DELEGATED DECISION TO DETERMINE PLANNING APPLICATIONS

Reference No:	2023/62/93286/W
Site Address:	25, Avison Road, Cowlersley, Huddersfield, HD4 5TL
Description:	Erection of two storey side and single storey rear extensions
Recommending Officer:	Joanna Rednall

DECISION – Conditional Full Permission

Proposed Floor Plans and Block Plan

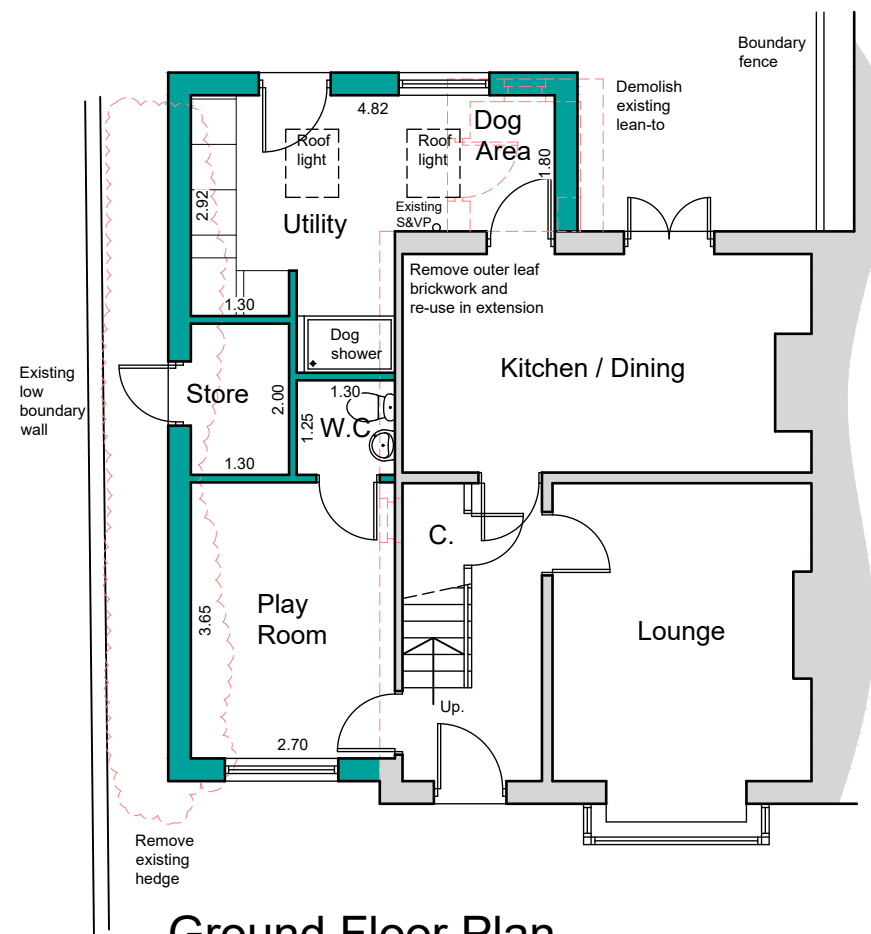
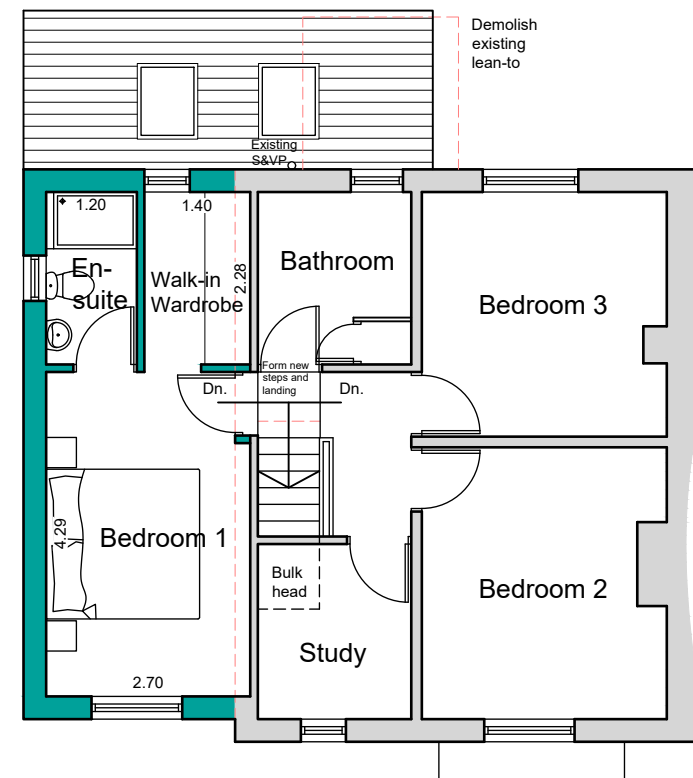
Request for justification of side extension projection not meeting SPD guidelines.

In terms of Principle 15 – the extension does not increase the total amount of bedrooms. The original Bedroom 3 will become a study due to its restrictive size and non-compliance with current standards. If off street parking is required for this proposal, I can discuss with my client.

Key Design Principle 15 states extensions and alterations should maintain appropriate access and off-street 'in curtilage' parking. As the dwellinghouse consists of 3 bedrooms, it would be required to provide 2 off-street parking spaces. However, it is noted that the existing dwelling has no off-street

parking available. Furthermore, no new bedrooms are proposed as part of the development therefore the level of parking/lack of parking space would be unaffected and would comply with KDP 15. The creation of parking spaces would likely cause an issue with highway safety due to the topography of the site and intervisibility with pedestrians. It would also impact on visual amenity through the loss of the garden area.

We attempted to step the extension back by 500mm but in doing so, we could not get a door into the playroom. We opted to still step it back but at a shorter depth in order to ensure the layout could be achieved, whilst also making the extension subservient to the host dwelling.

Proposed Elevations

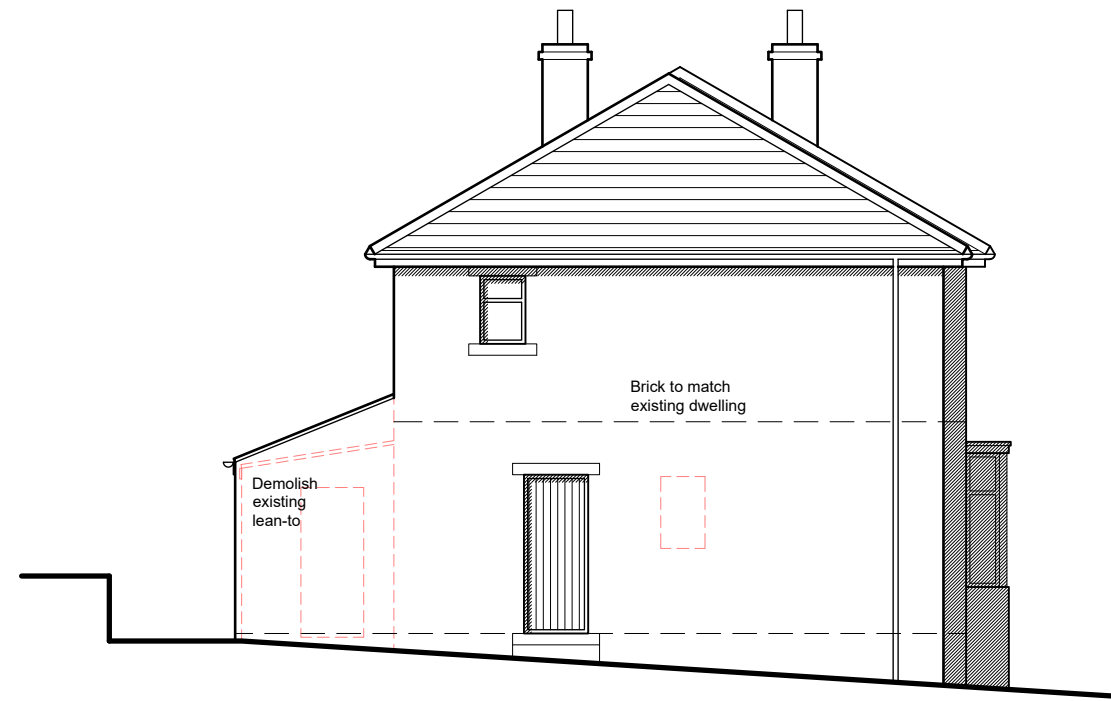
The extension would appear visually smaller in relation to the original house. However, the 300mm set back would not comply with the parameters set out above. This design has been justified by the agent to facilitate sufficient internal space for a door into the playroom, and it is considered that the proposed 300mm would be sufficient in this case and would appear well-proportioned in relation to the existing dwelling. The roof design would be hipped to match the host dwelling. In addition, the roofline of the side extension would be approximately 200mm below the existing which would likely complement the design and reduce the overbearing appearance of the extension on the street-scene. In terms of the existing streetscene, the extension would likely balance the appearance of the two-storey extension at the attached neighbour No. 27 Avison Road (ref:2000/92108). In terms of visual amenity, this would likely balance and be proportionate to the existing dwelling and the street-scene and would comply with the Key Design Principles 1 and 2.

The extension would retain approximately an approximate 0.9 metre gap between the side elevation and the shared boundary with No. 23. This neighbour is approximately 1.6 metres from the shared boundary, therefore it is unlikely that the extension would create an overbearing and terracing effect. Rear access to the garden would be retained and it is unlikely it would benefit the visual amenity by reducing the side projection by ~0.2 metres, and would therefore comply with KDP 1 and 2 of the SPD.

No.23 is a detached bungalow on the side (north-east) facing elevation of the application property. This neighbour has a window on the side (south-west facing) elevation which would be approximately 2 metres from the side elevation of the extension. A first-floor window is proposed on the south-west facing elevation on the application dwelling which would serve a bathroom. However, it was confirmed by a site visit that the window on No.23 is obscure glazed and would therefore be highly likely to be a window for a non-habitable room. This would mitigate the impact of privacy despite the 12-metre recommended distance not being met, complying with KDP 4. In addition, the proposed window at No.25 would be on the first floor and would not directly face any opening at this neighbour.
